**Harnett County**  
420 McKinney Pkwy  
LILLINGTON, NC 27546  
Phone:  
Fax:

**SUBJECT: BRES2212-0014**  
**BUILDING RESIDENTIAL**

Here are the results of all Inspections located at **310 WYNDHAM PLACE DR:**

FRONT VIEW

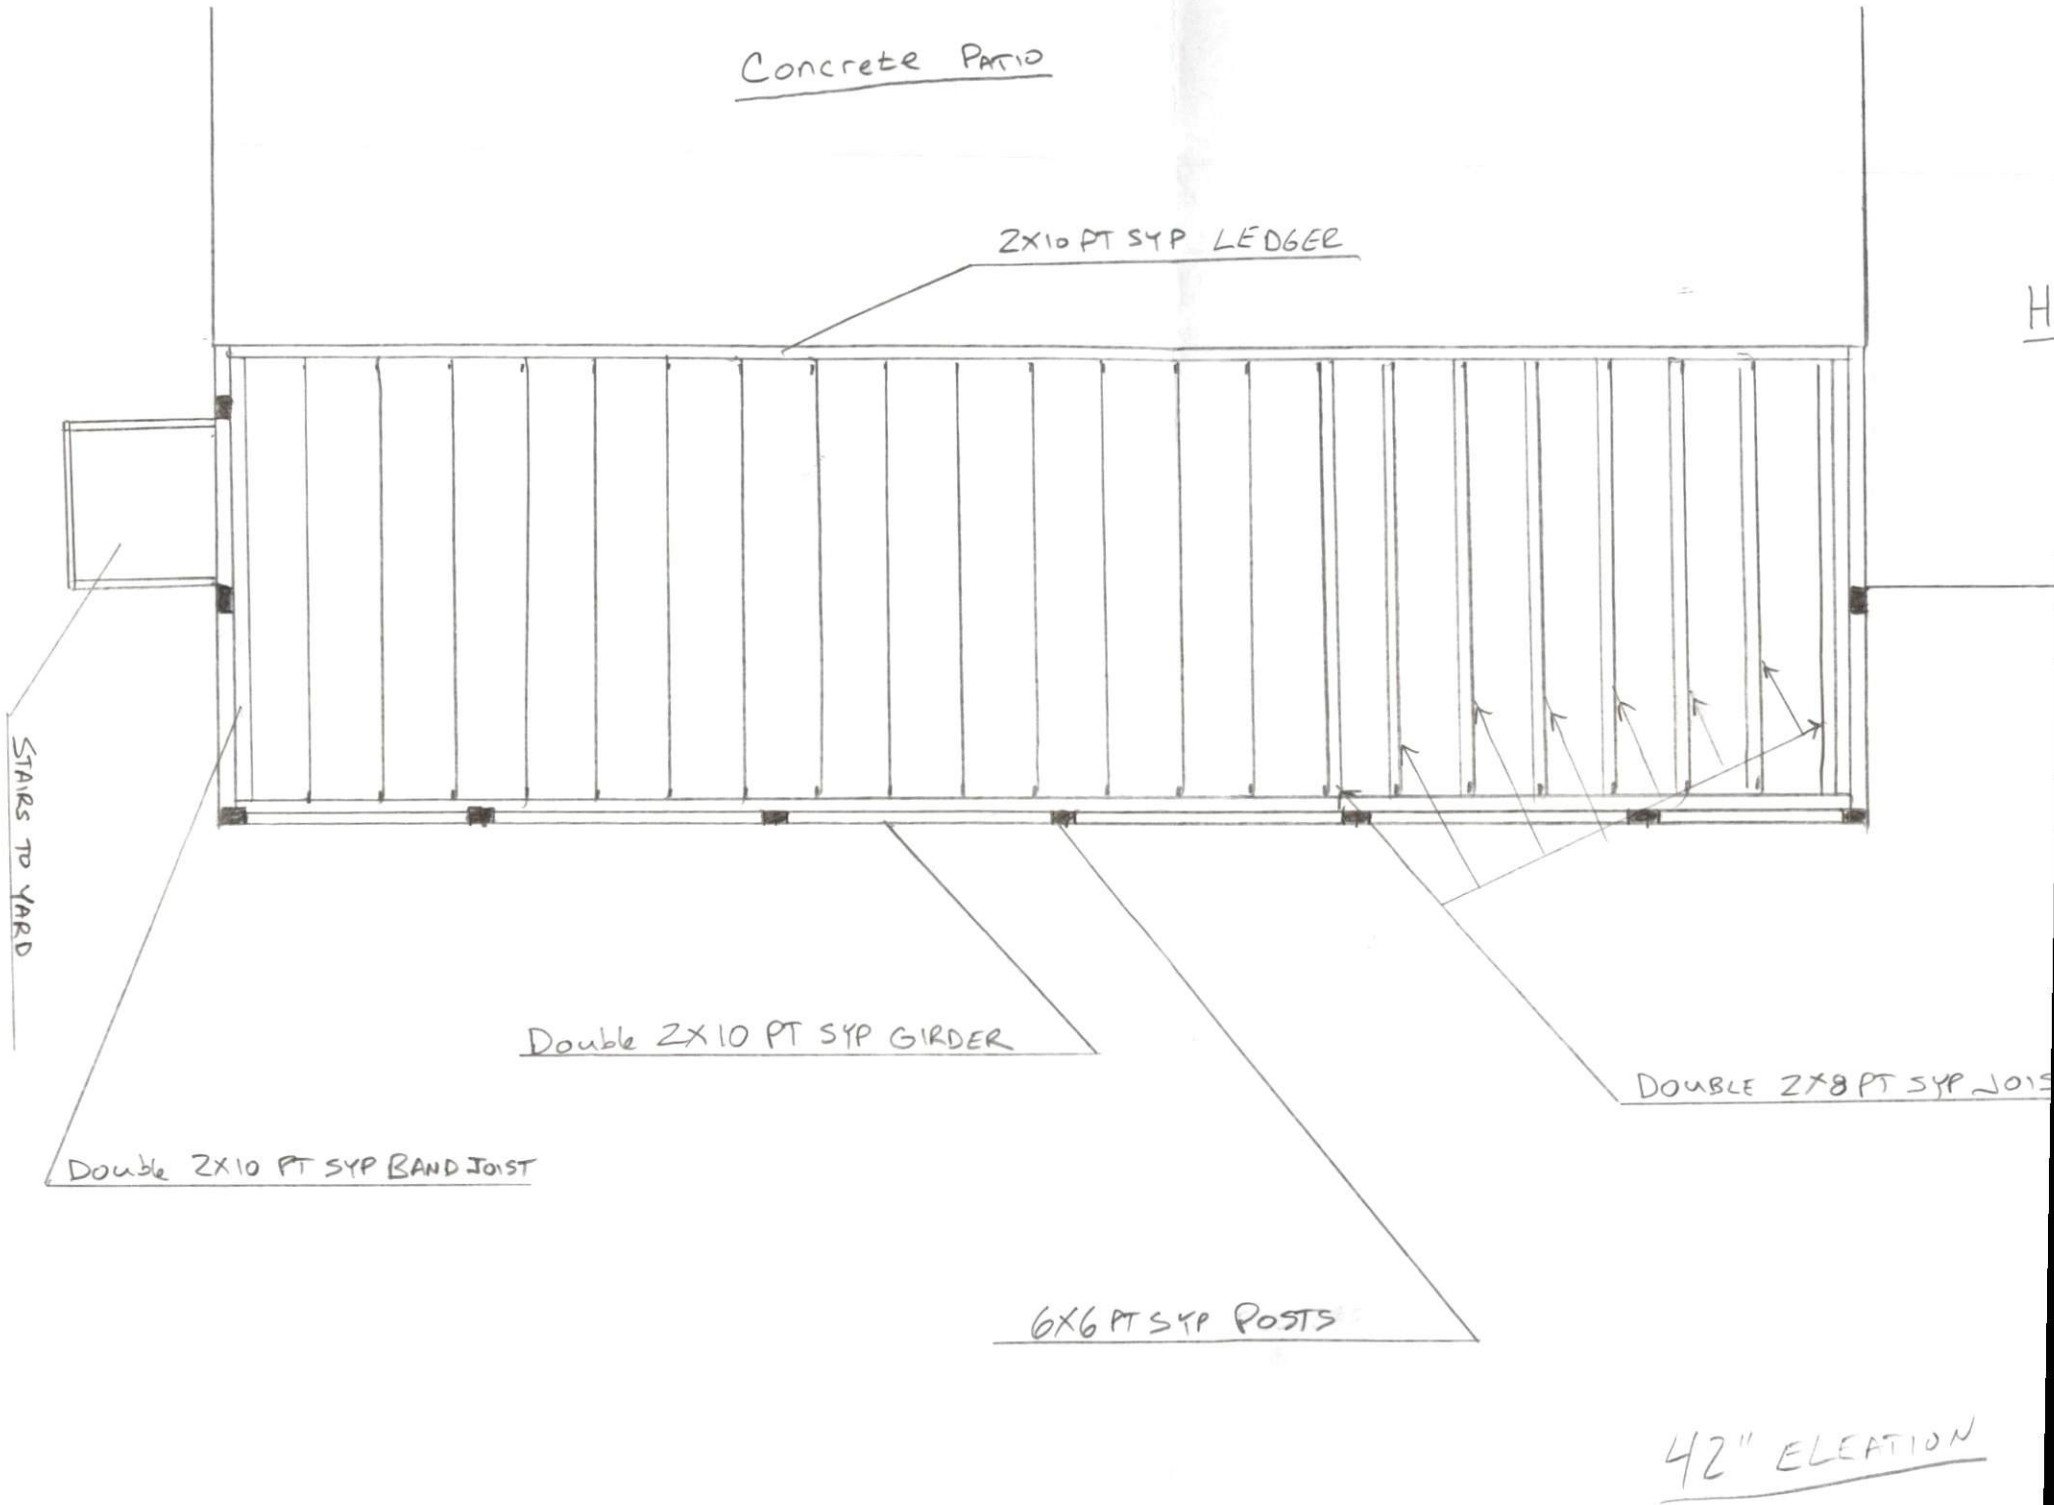
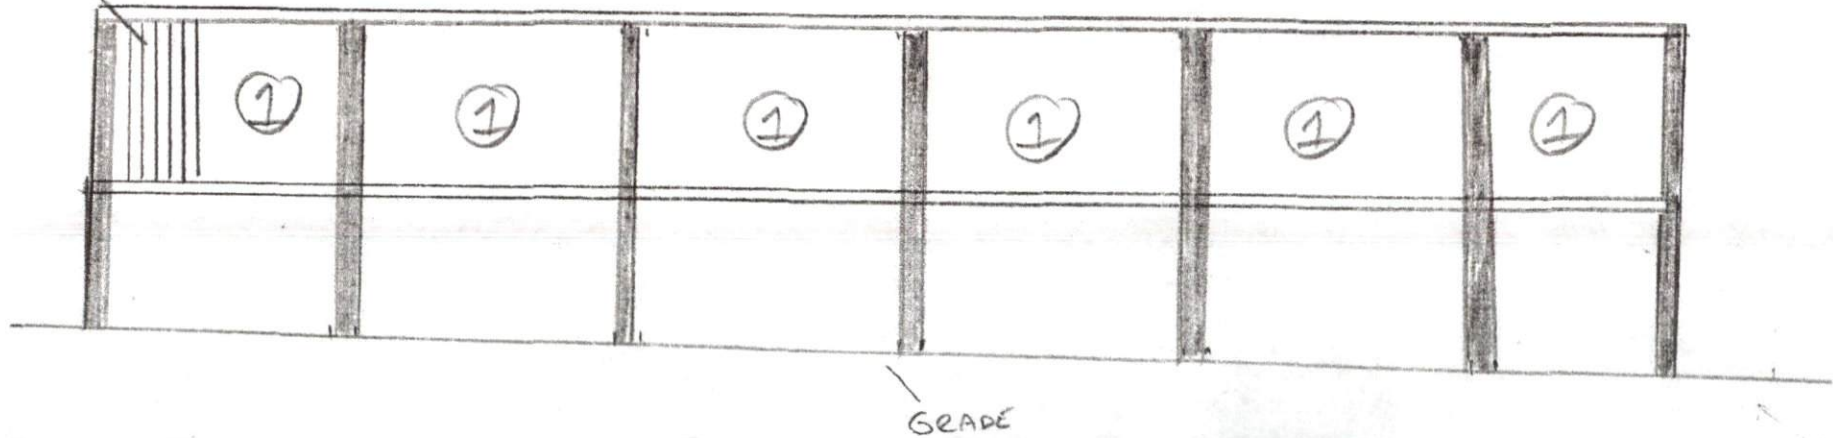
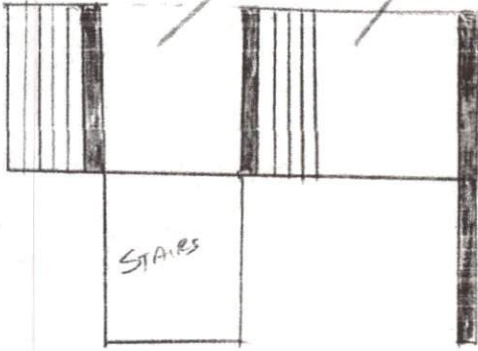
Notes: 1-(dirt) landing at bottom of step is required to be 3x3. 2-right side of step requires a guardrail .  
This area is great than 30" in height.
